DRB CASE ACTION LOG (PREL & FINAL PLAT)

DRB Application No.: 05DRB-01629 (P&F)

Project # 1004507

Project Name: DICKS ACRES SUBDIVISION

**PLAT OF
LOTS 4-A, 4-B AND 4-C
DICKS ACRES SUBDIVISION**

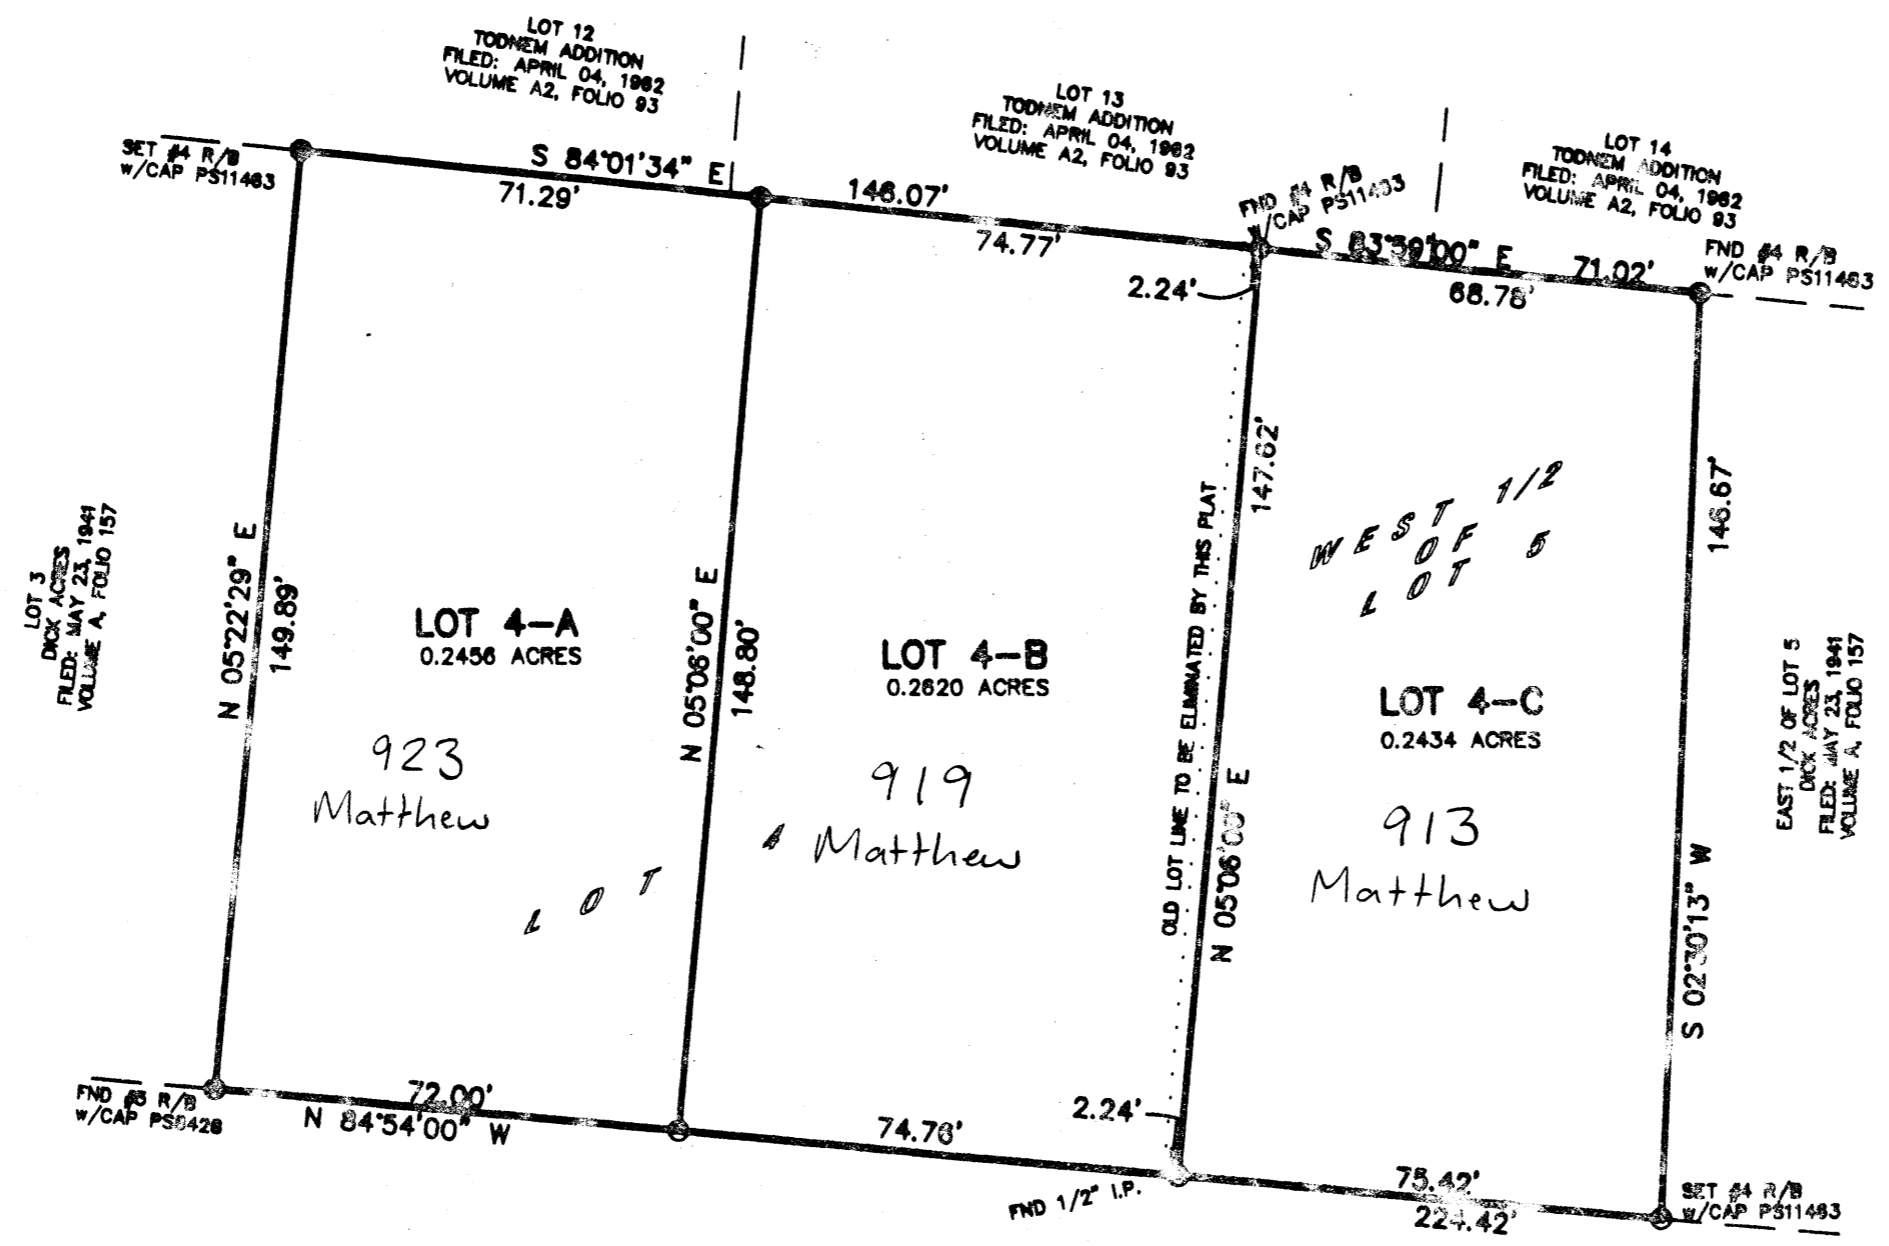
TRANSPORTATION: - ROAD ESTATE ROAD
 - 9' to PROPERTY LINE for edge of ROAD
 - DEMOLITION PERMIT REQUIRED
 for 913 Matthew
 Cade
